Application for a Non-Material Amendment Following a Grant of Planning Permission

Land at Yiewsley Library and Former Yiewsley Pool,

76795/APP/2023/2503

Non-Material Amendment(s) Sought

NMA - South East,South West&North East Elevations 05, 06, 07 & 08

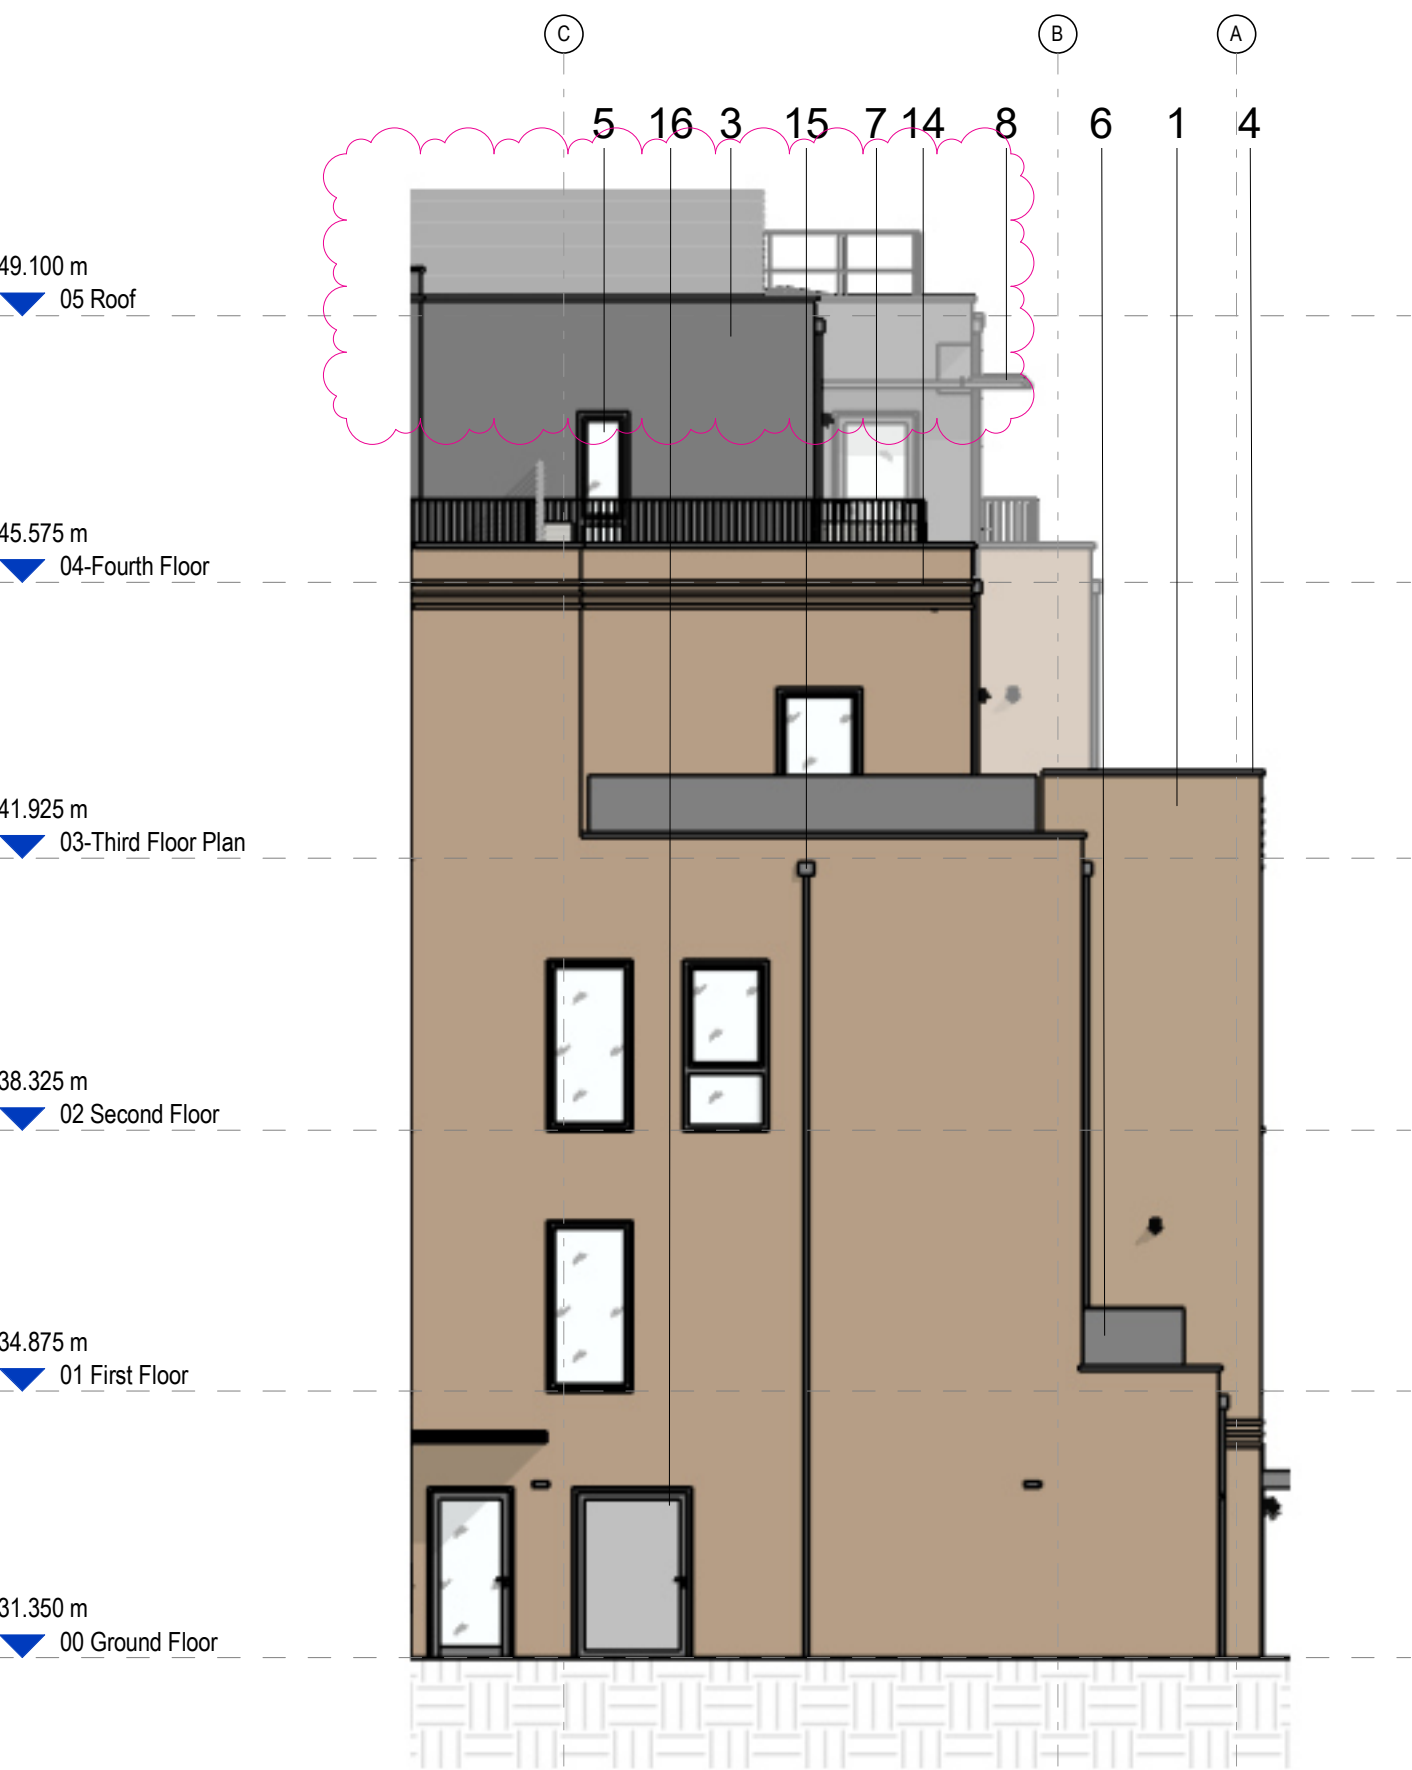
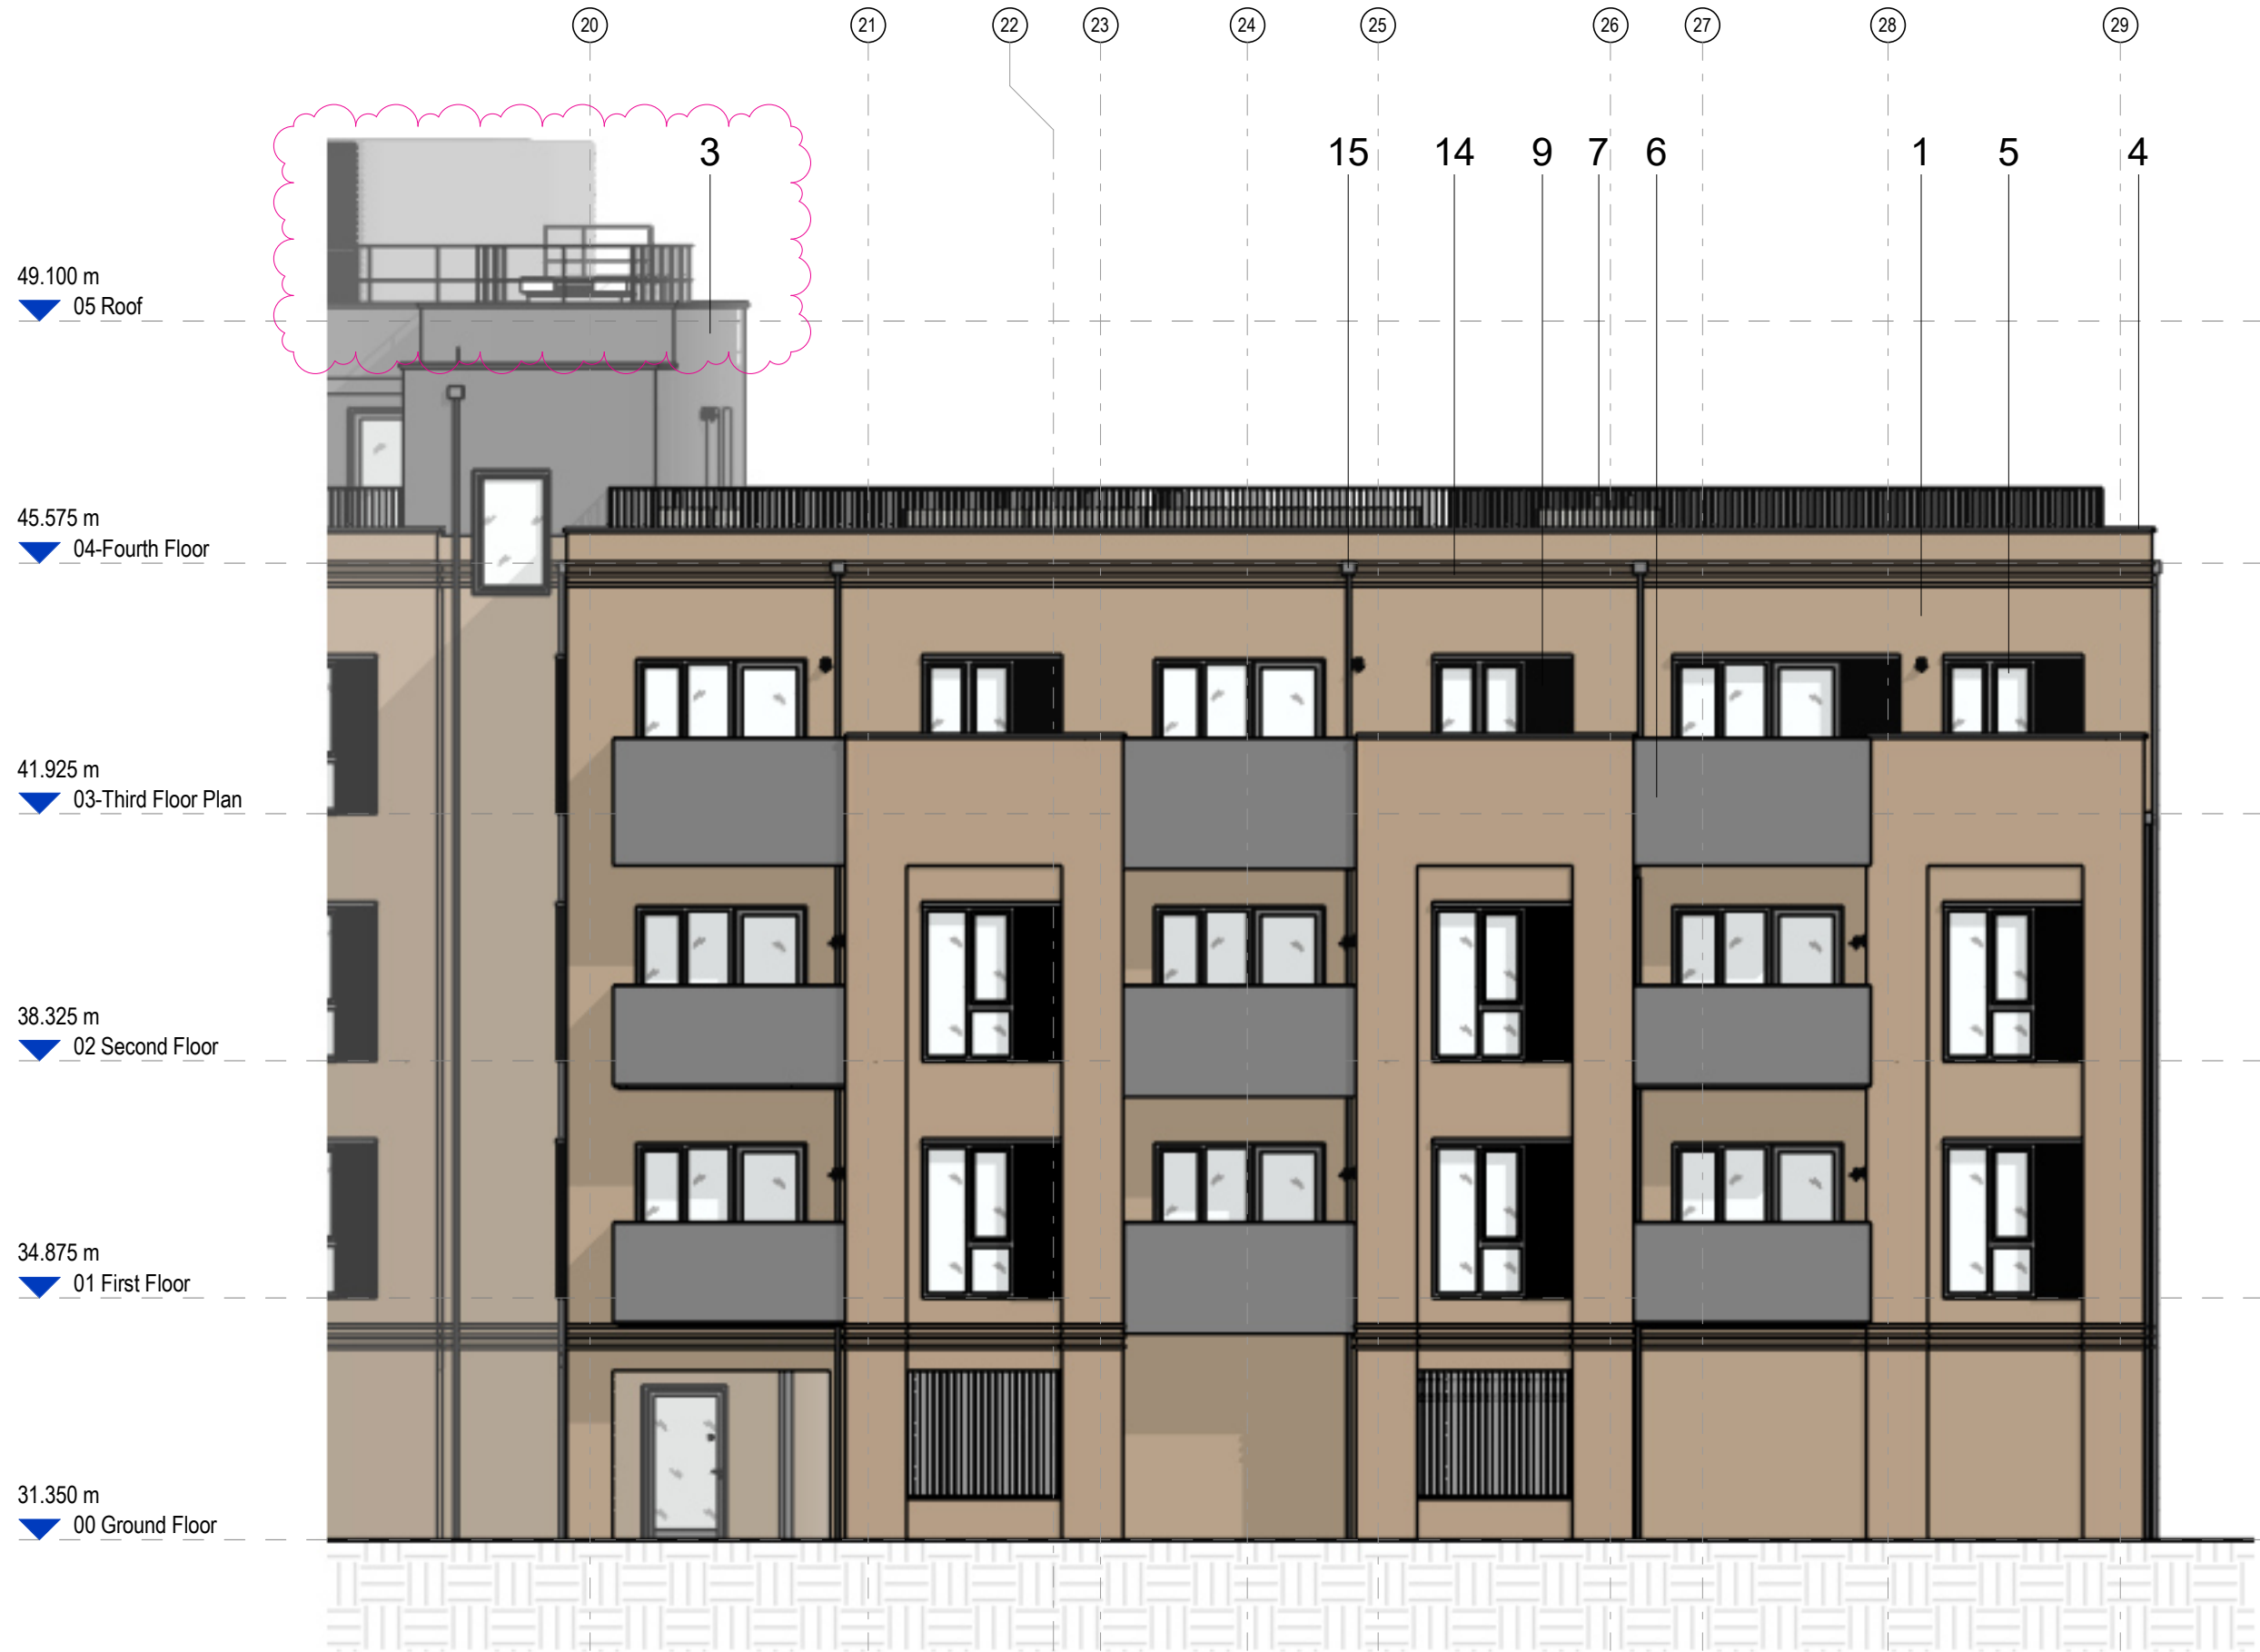
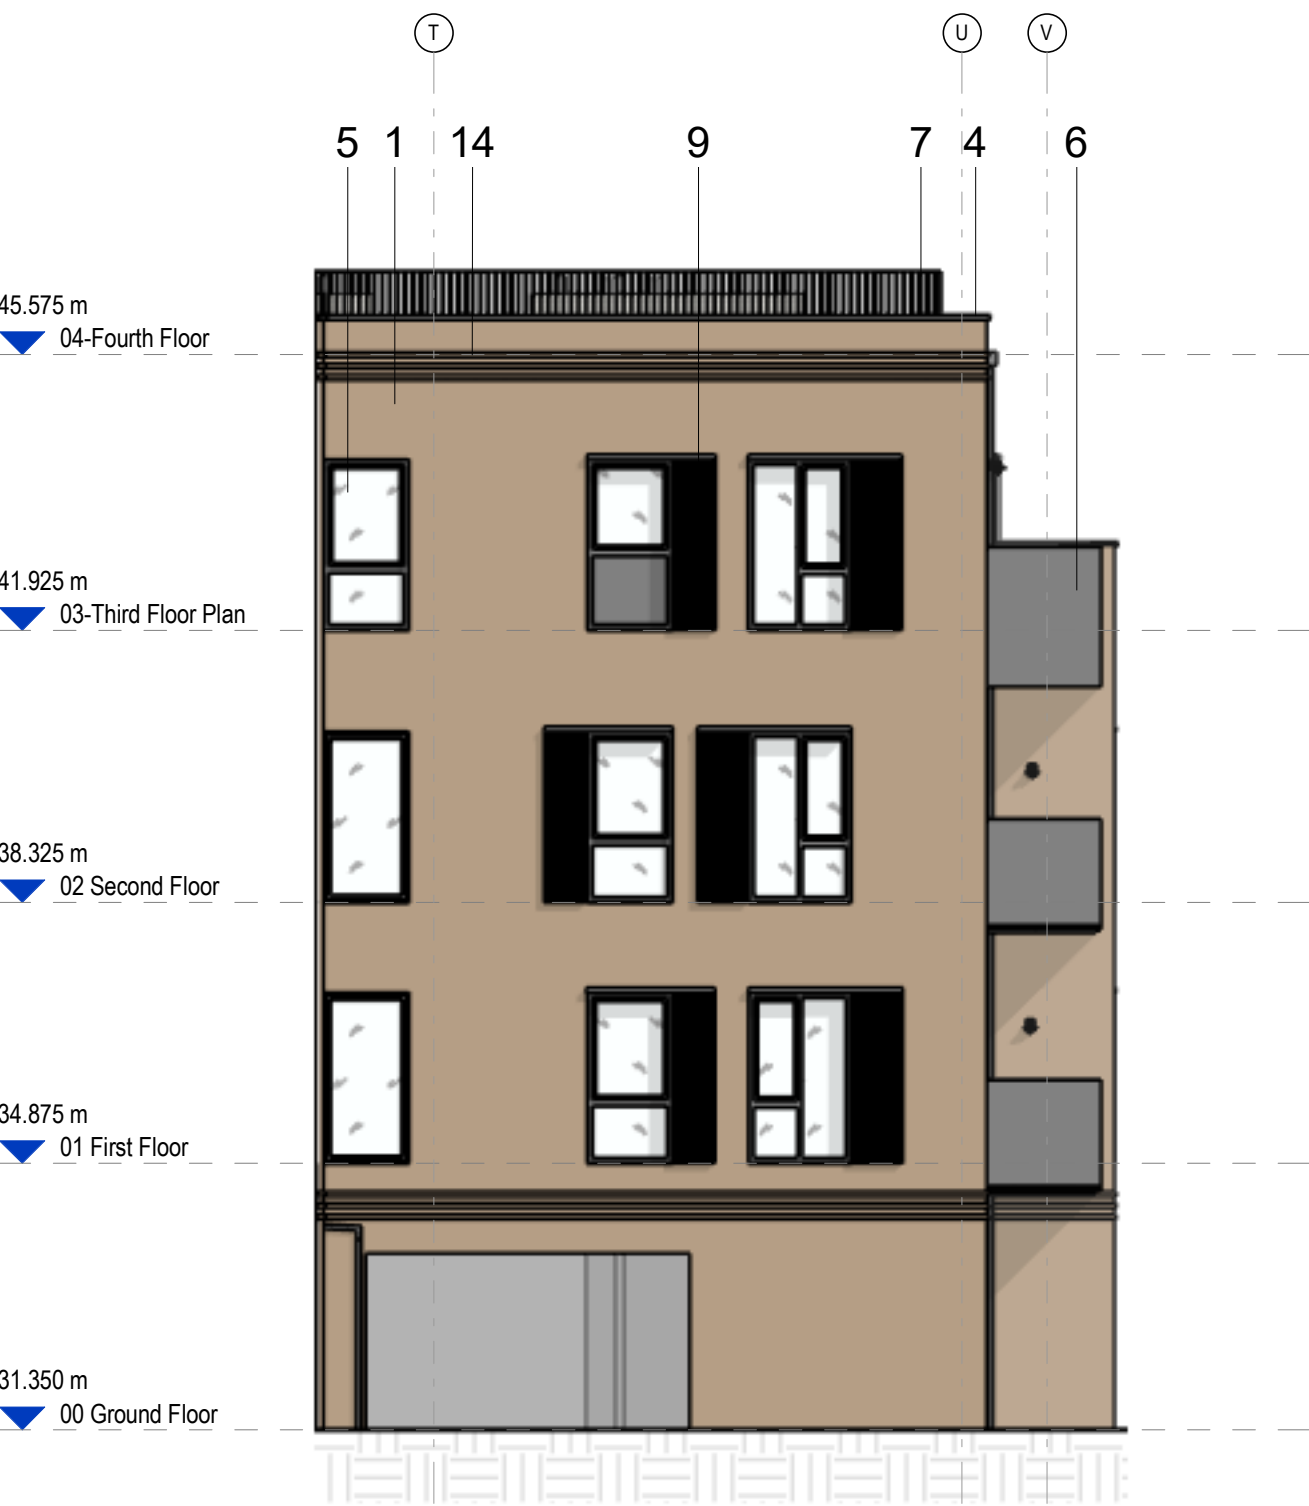
Louvers and shutter added to Rabbsfarm car park – The Shutter is a Secure by Design requirement and ventilation requirement for fire strategy.
